KIRKLEES METROPOLITAN COUNCIL

UPDATE OF LIST OF PLANNING APPLICATIONS TO BE DECIDED BY

PLANNING SUB-COMMITTEE (HUDDERSFIELD AREA)

13 DECEMBER 2018

## Soakaway Test

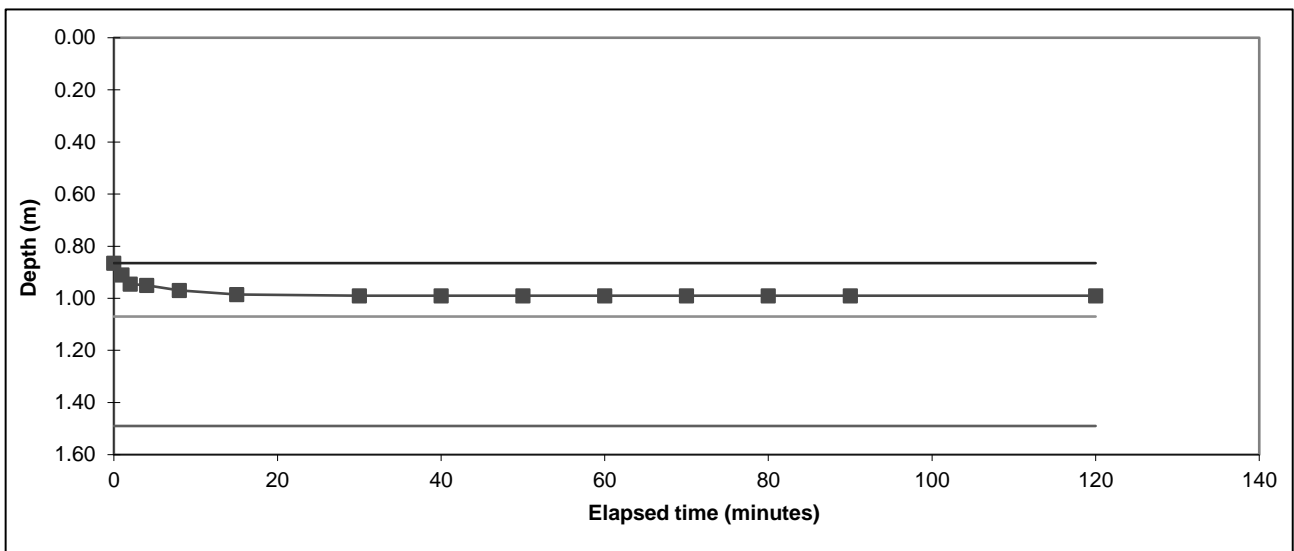
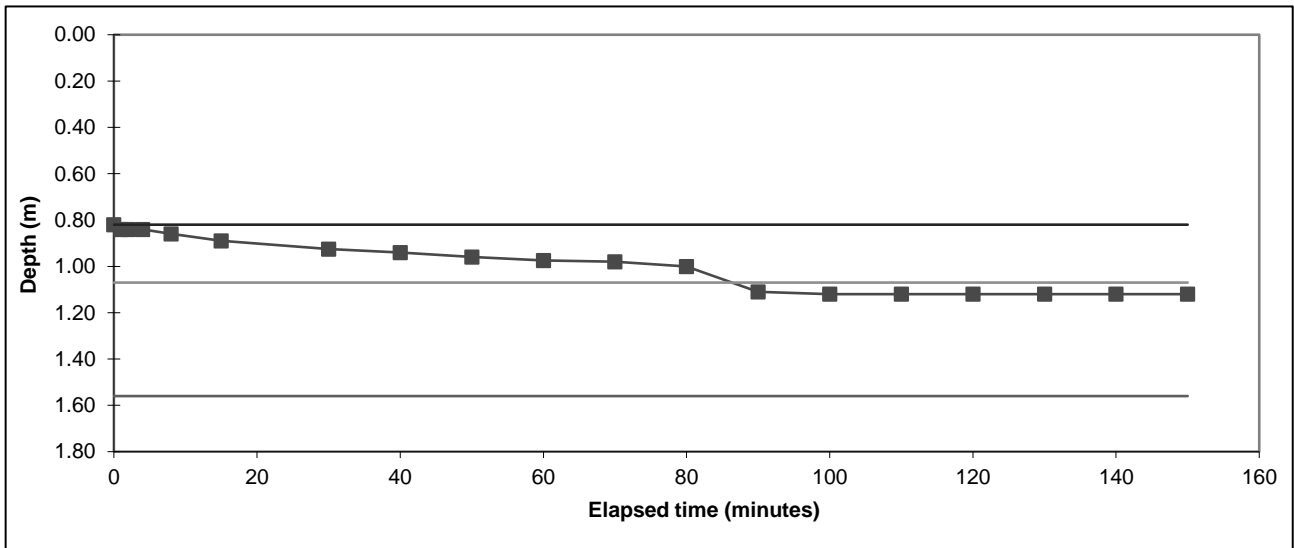
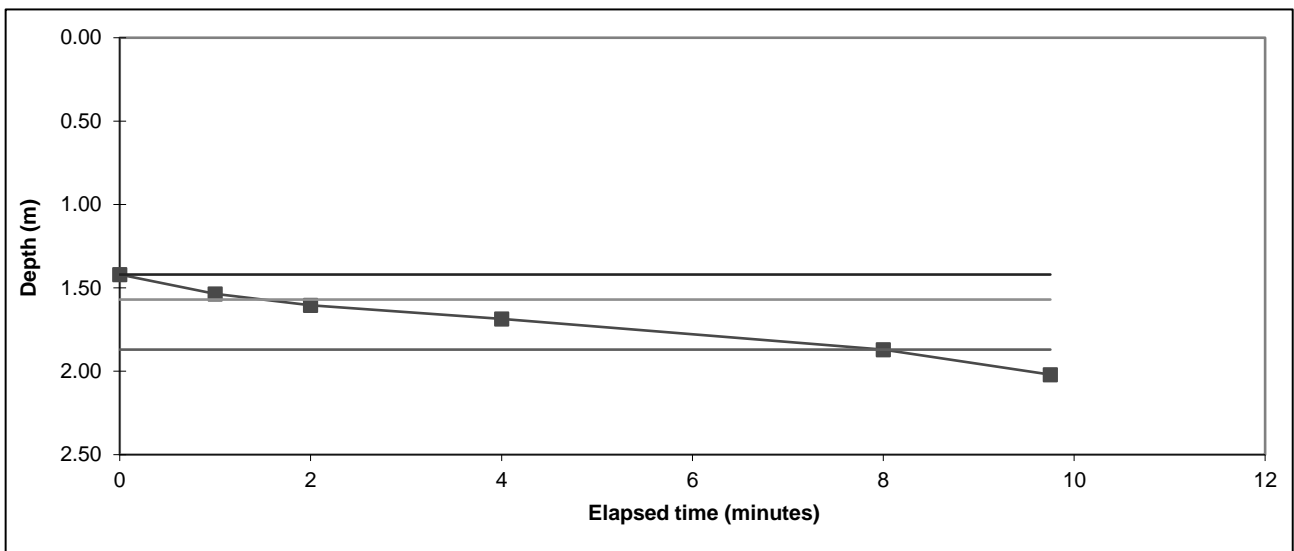
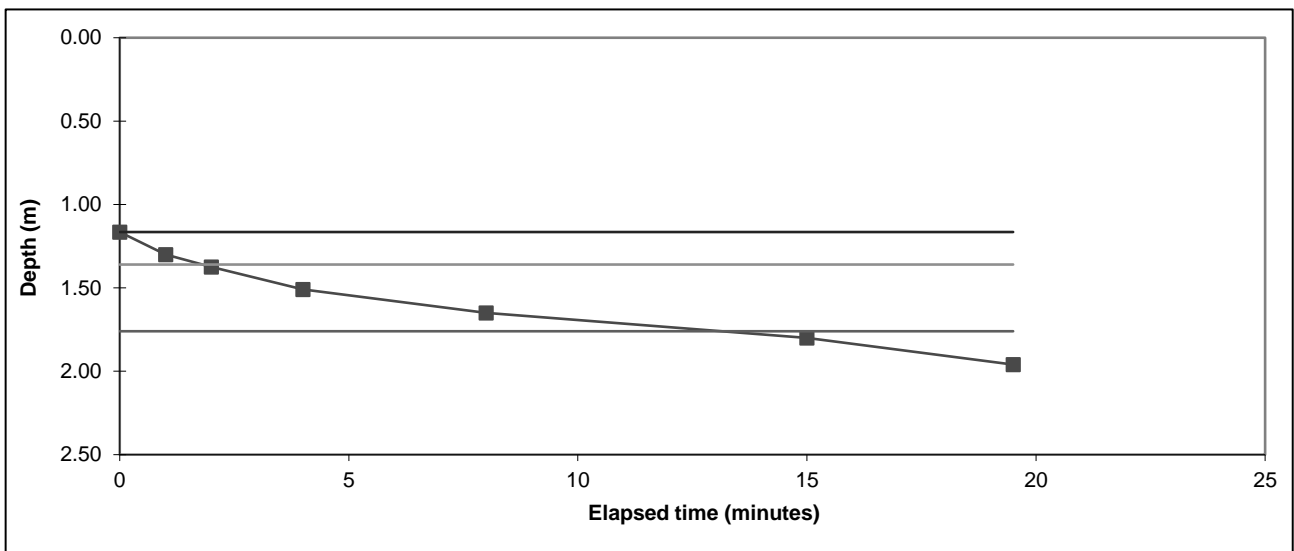
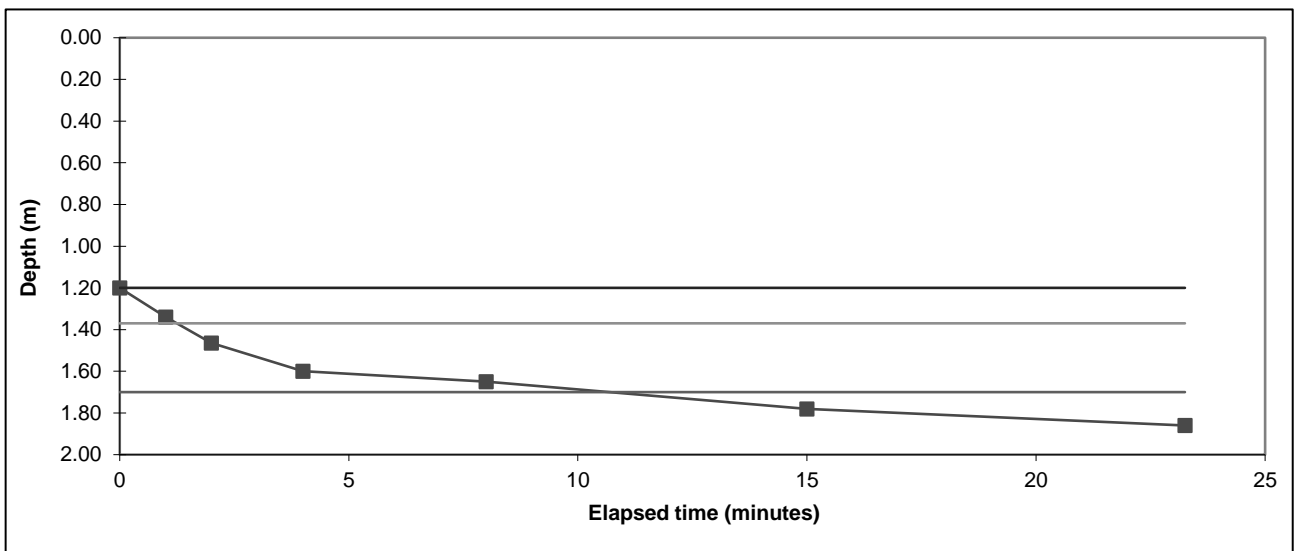
The drainage strategy that has been submitted shows the use of a soakaway. However, the LLFA maintain their objection as there are concerns with the soakaway testing undertaken. In short, there is insufficient detail to properly understand the acceptability of surface water drainage on this site.
